From: Bloomer, David <David.Bloomer@lancashire.gov.uk>
Sent: 14 September 2017 09:31
To: Adam Birkett
Cc: LHS Customer Service; planning
Subject: App/3/2017/ 0602 Land at Higher College Farm

The proposal is for outline planning permission with all matters reserved except for access. In this respect there are a number of issues which would need to be addressed before the proposals would be considered acceptable

Land at Higher College Farm, Longridge
Proposed Access Drawing

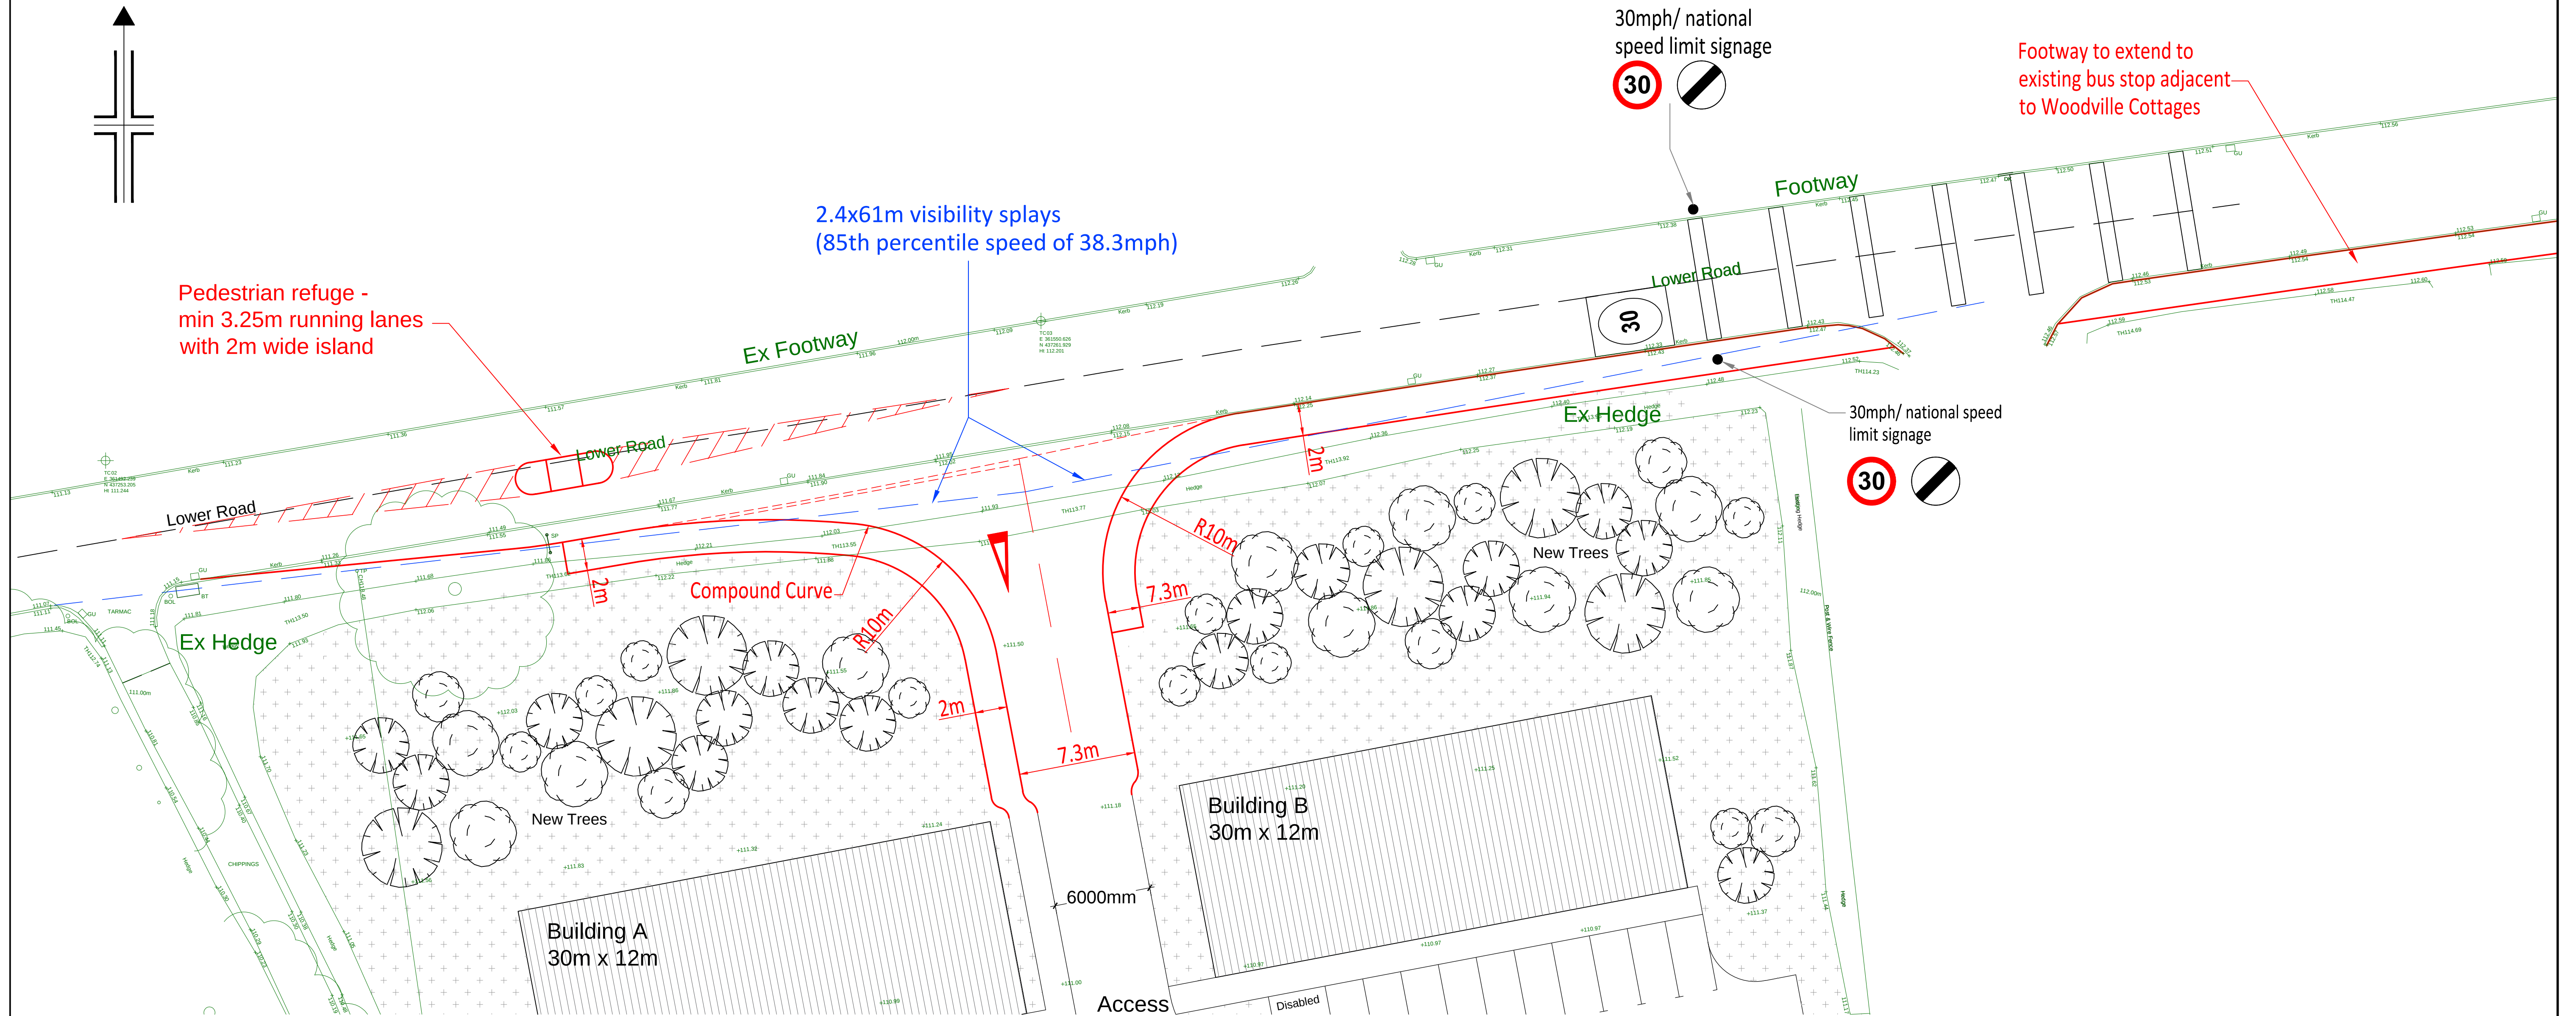
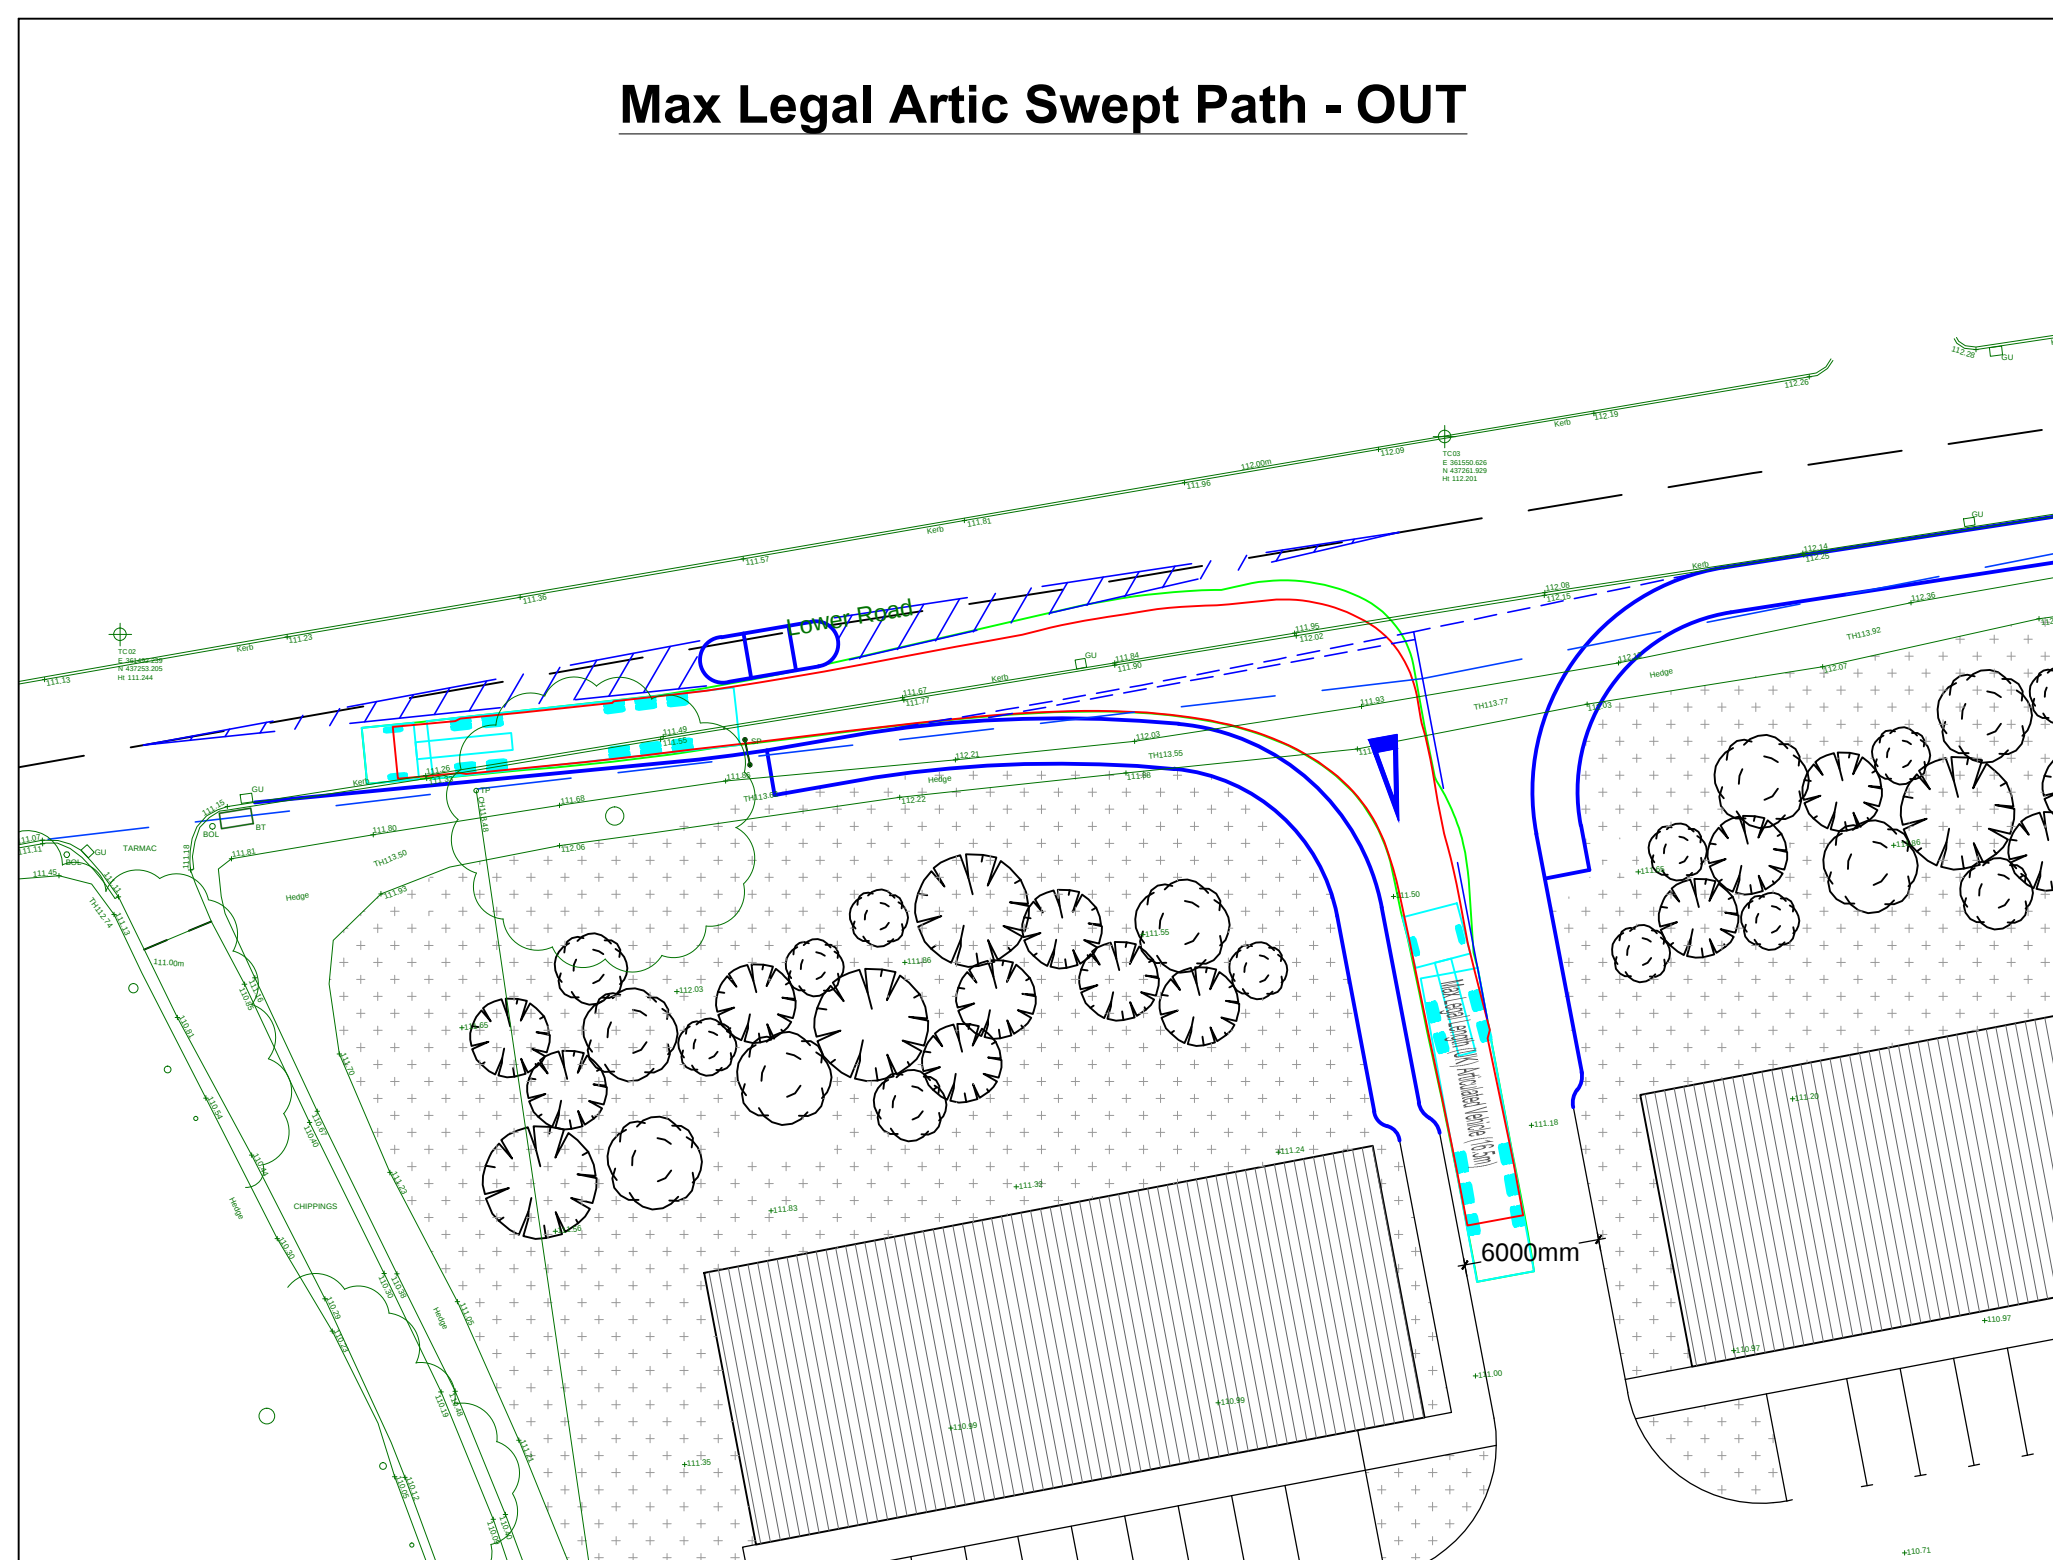
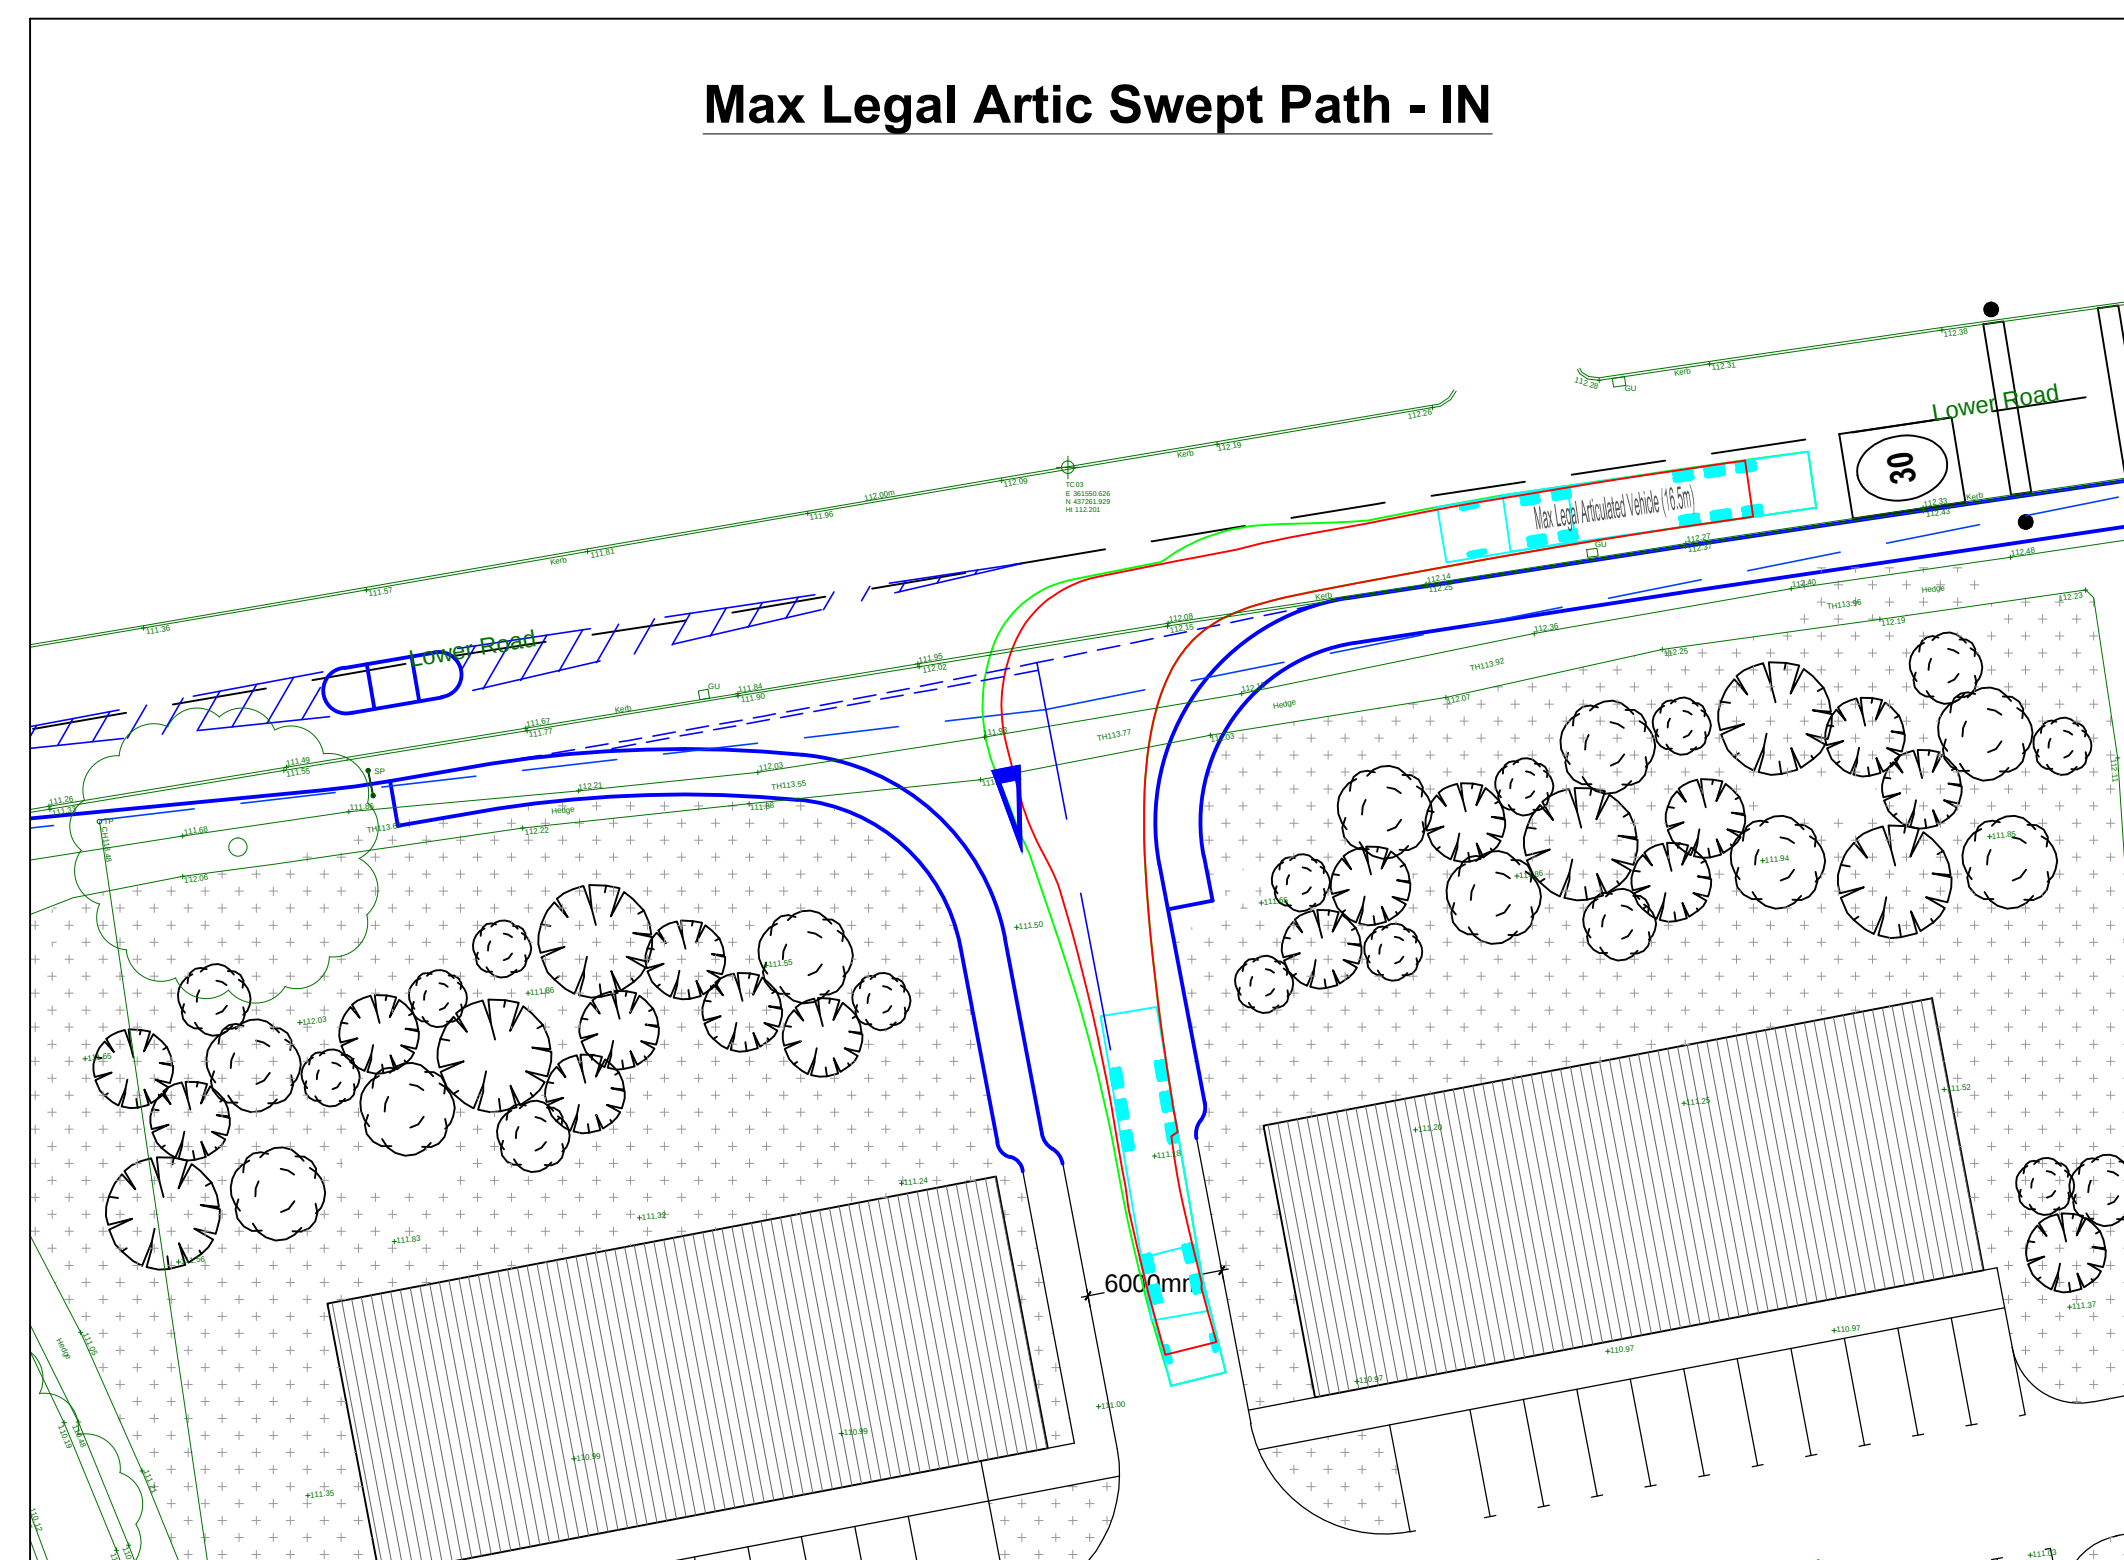
1 The access proposed is 7m wide with a 7m radius. Dimensions of 7.3 and 10m respectively would be required.

2 A footway will be required along the easterly side of the proposed access road and this should be continued along the south side of Blackburn to the existing bus stop adjacent too to Woodville Cottages.

3 No swept path analysis has been undertaken for vehicles entering / leaving the site

Proposed Works To Junction (Corporation Arms)

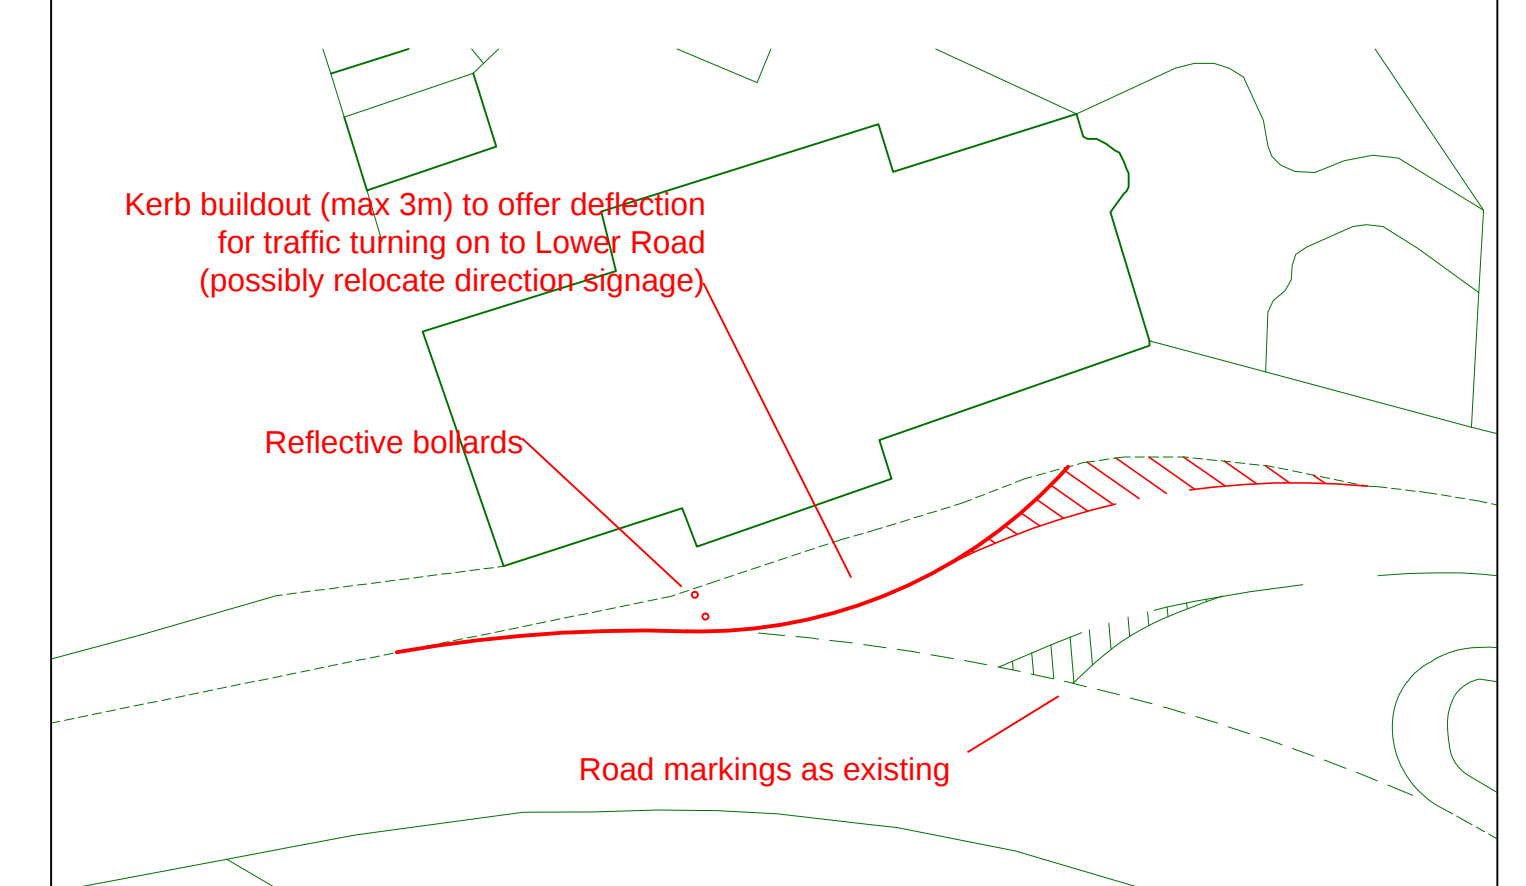
As with the adjacent application, a highway safety issue has been identified at the Corporation Arms junction and the applicant would be expected to propose a scheme at this junction to address these concerns.
